**CITY OF ALBUQUERQUE
PLANNING DEPARTMENT
June 4, 2014
DRB Comments**

PROJECT # 1004976

**RE: Black Arroyo Dam - Golf Course Road Vacation/ Subdivision
Design Variance from minimum DPM standards**

ALBUQUERQUE, NEW MEXICO  
 APRIL, 2014

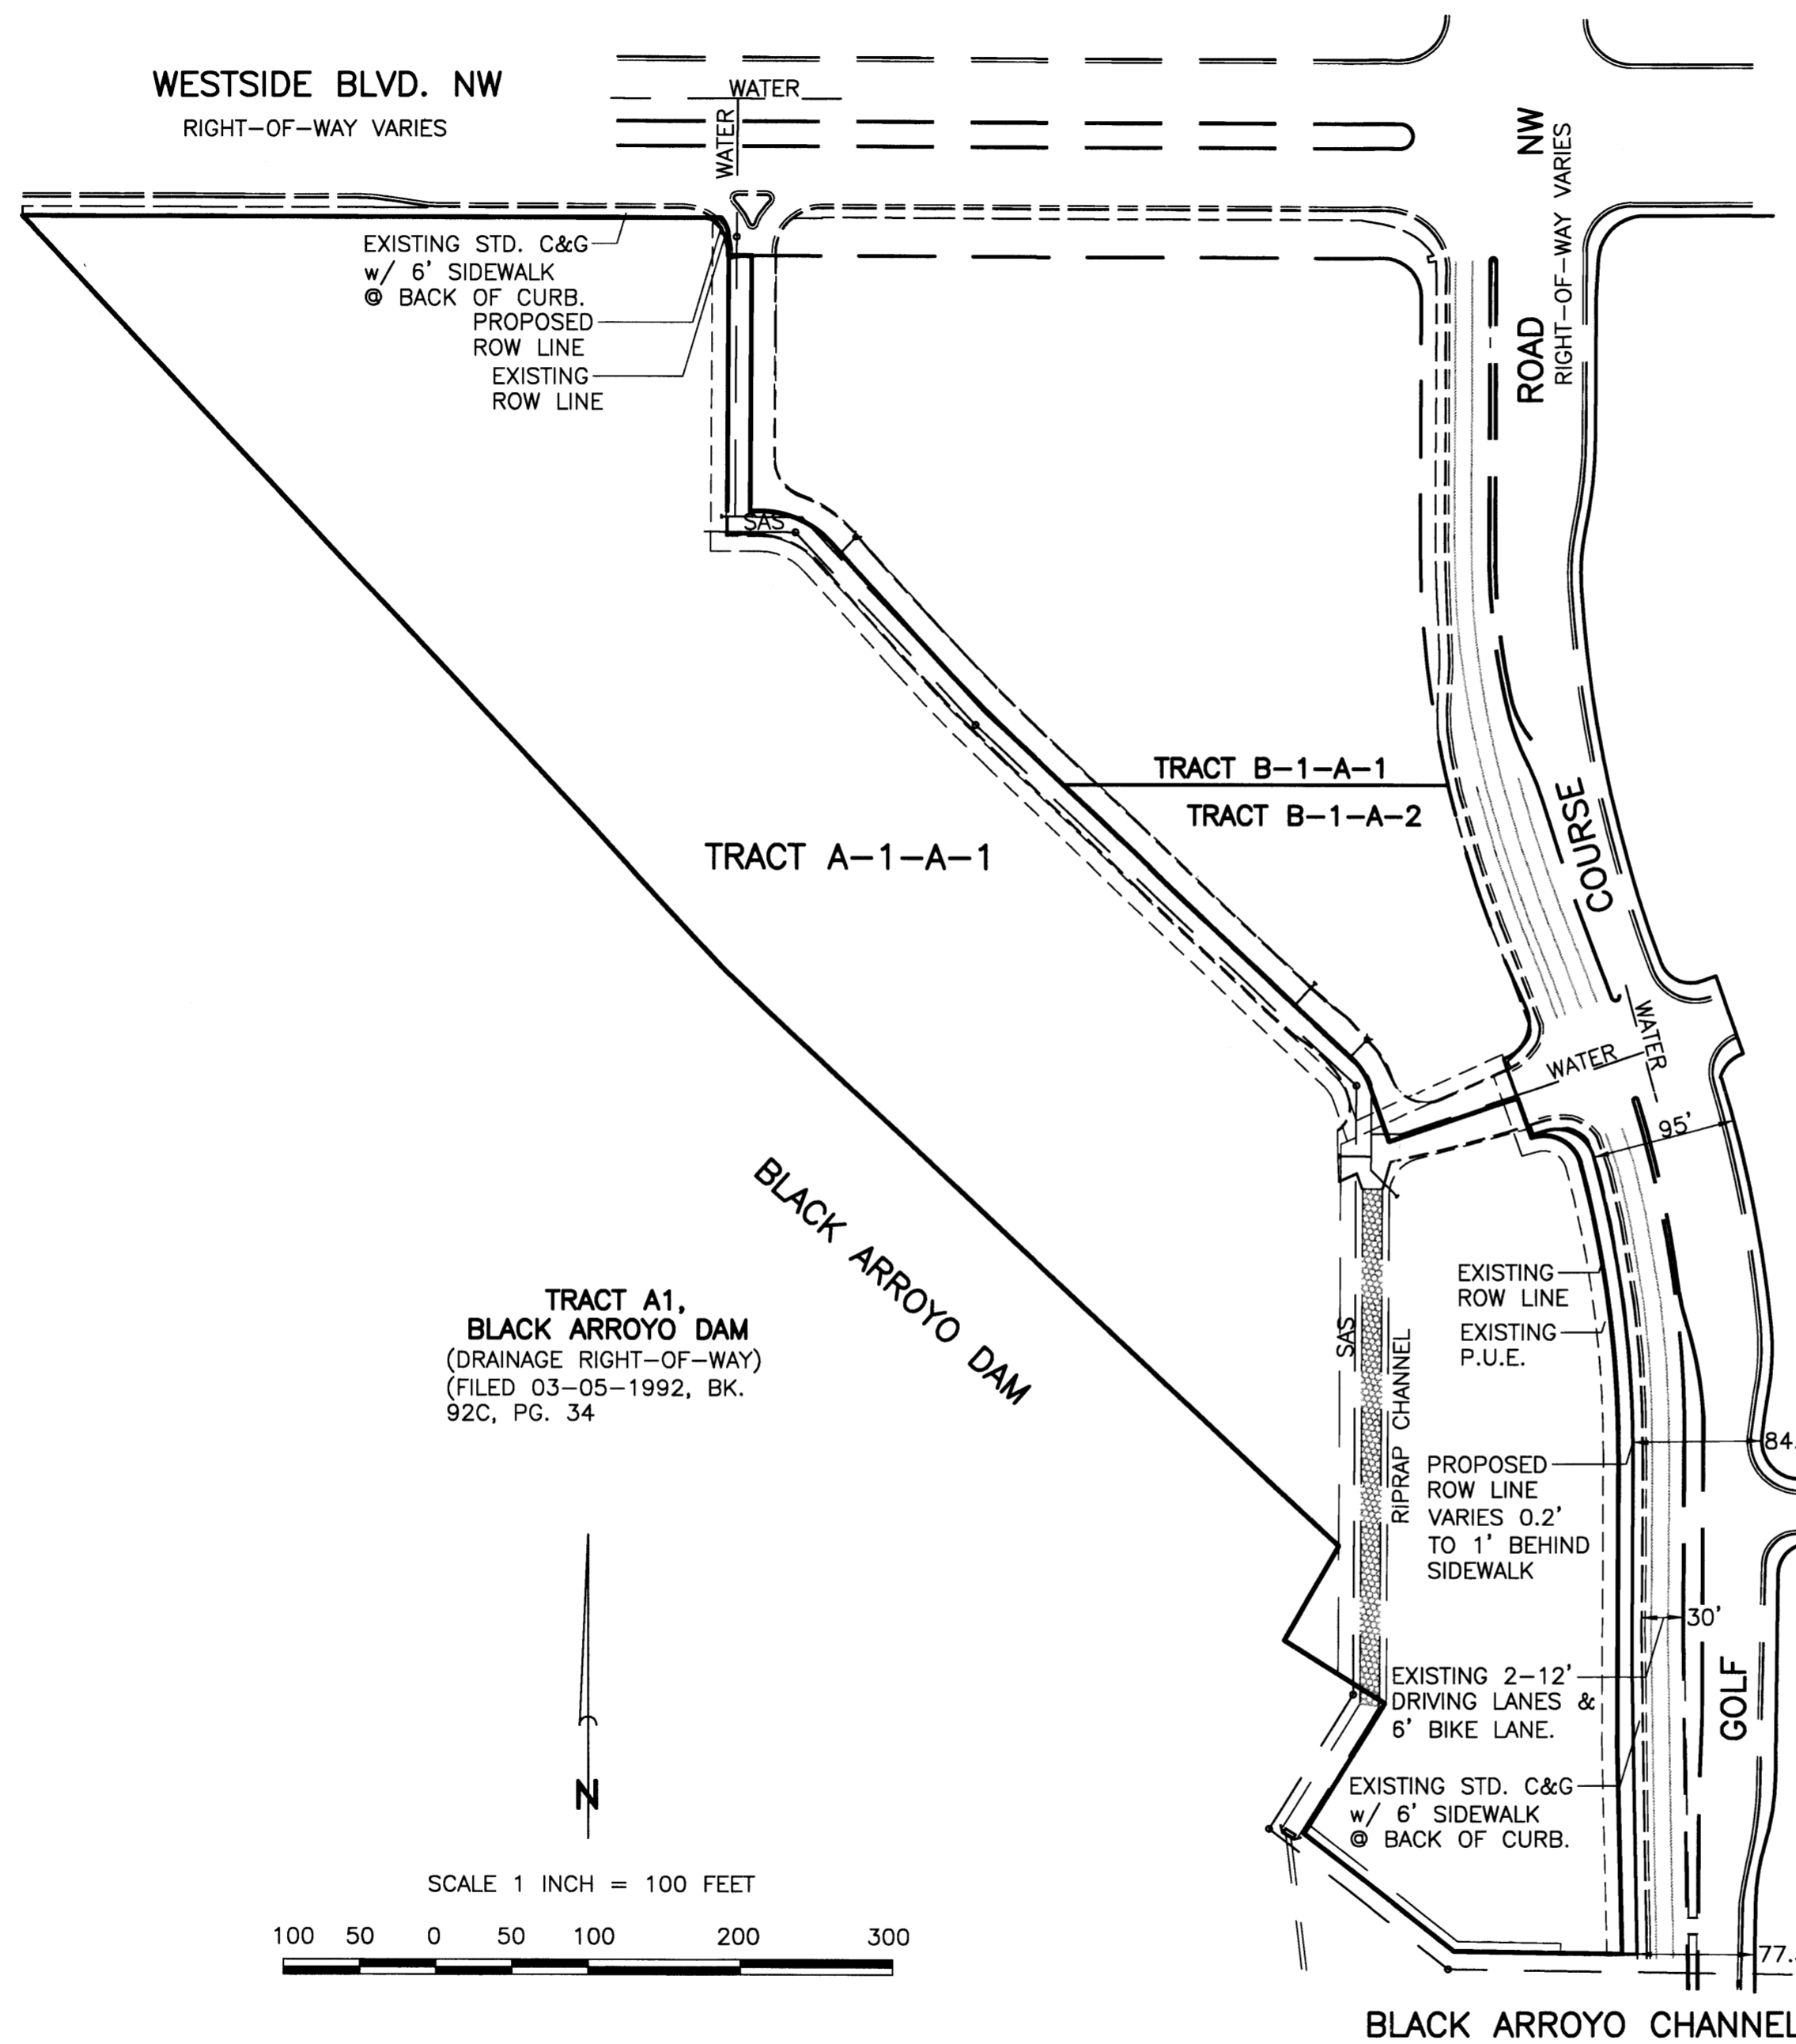
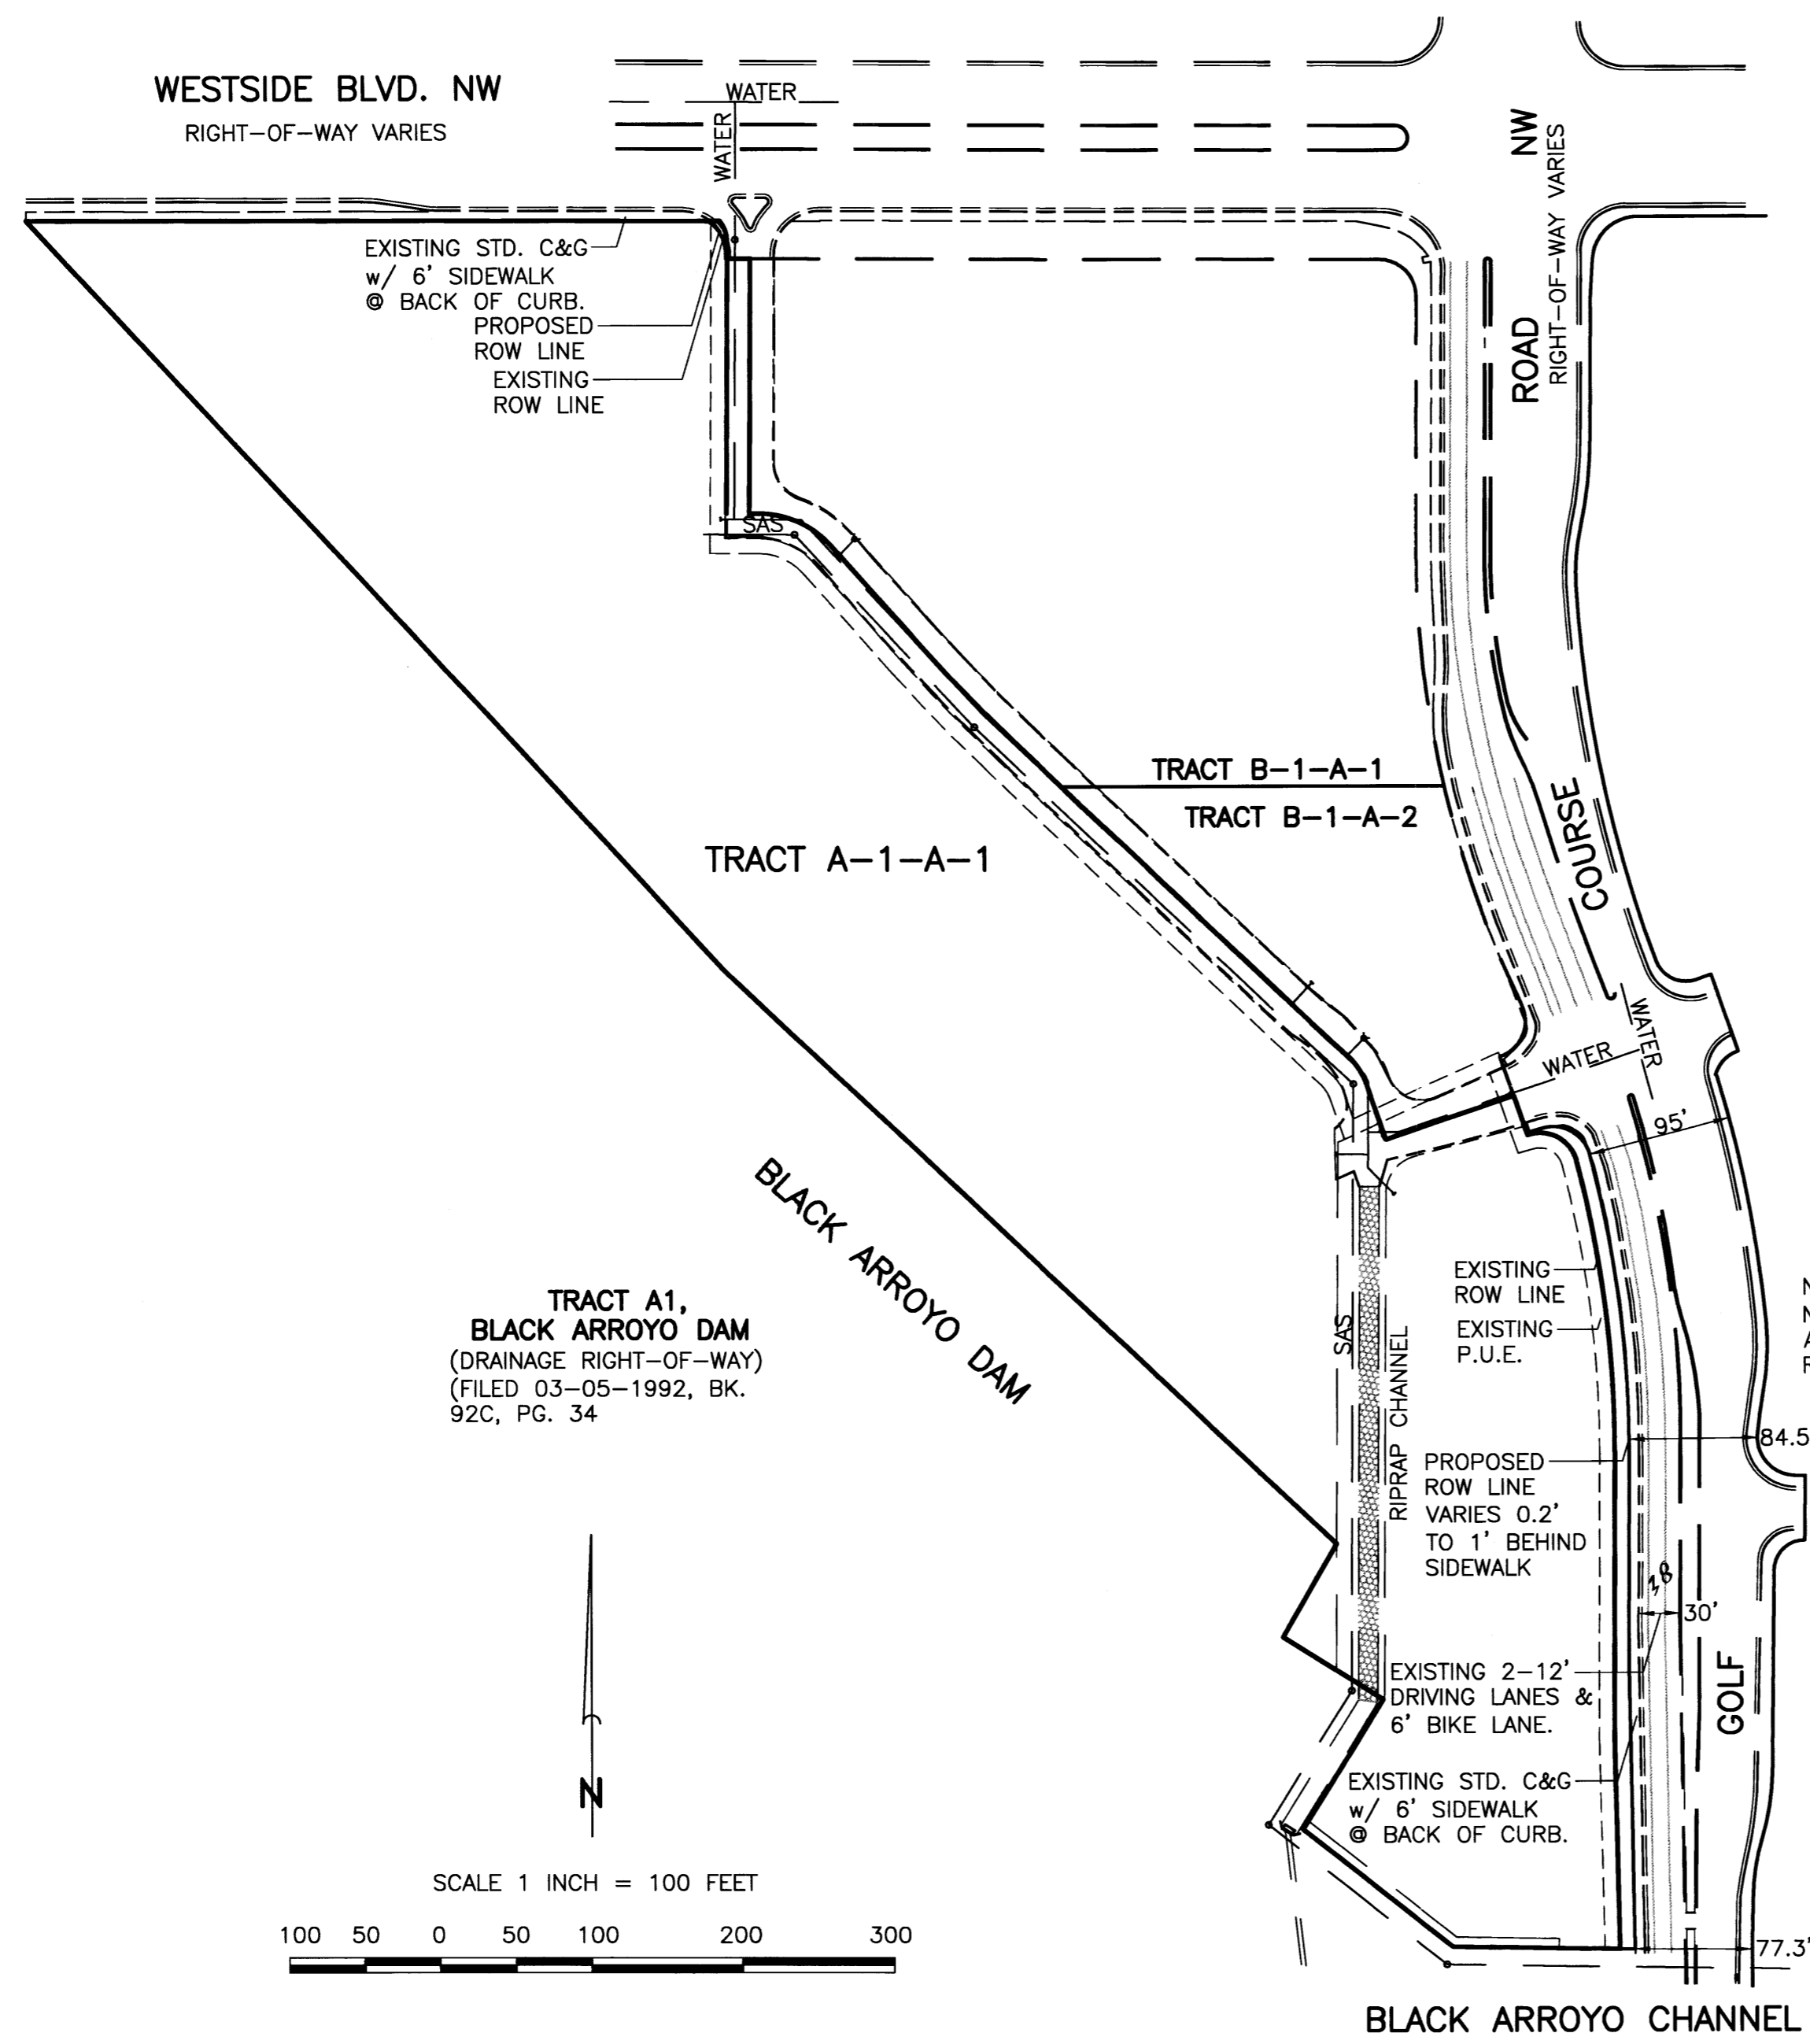
Regarding justification for the proposed vacation, it needs to be demonstrated how the public welfare is in no way served by retaining the right of way. Additional right of way is often provided outside of public improvements for maintenance, emergency access for repairs, etc. and it is unclear how the existing right of way is not needed to serve these public welfare issues. Alternatively, it needs to be demonstrated/ calculated how the development made possible might outweigh the detriment of relinquishing the right of way for the issues previously noted (also see 'Justification for design variance' below). Finally, a review of the file 1002556 does not show a vacation across from the current request but rather a dedication for a deceleration lane (in exchange for vacation to the north). The distance from back of curb to property line was noted as 10 feet; again, this was adjacent to a deceleration lane which is not the same as being adjacent to an arterial travel lane.

Regarding justification for a design variance, it needs to be demonstrated via a site sketch that there is a practical difficulty in providing an internal private roadway which cannot be accomplished with the existing right of way boundary. The property developer will be responsible for landscaping all of the lot's frontage via site development plan approval whether it is in right of way or not.

- 1) Call out dimensions and indicate total R-O-W and pavement widths, both existing and proposed --- the only additional data that was submitted is a partial call out for "EXISTING 2-12' DRIVING LANDES 7 6' BIKE LANE." The necessary exhibit should be devoted to the area in question adjacent to Tract A-1-A-1 and should

include dimensions for the existing plus proposed distances from back of curb to property line, as well as calculate the area proposed for vacation.
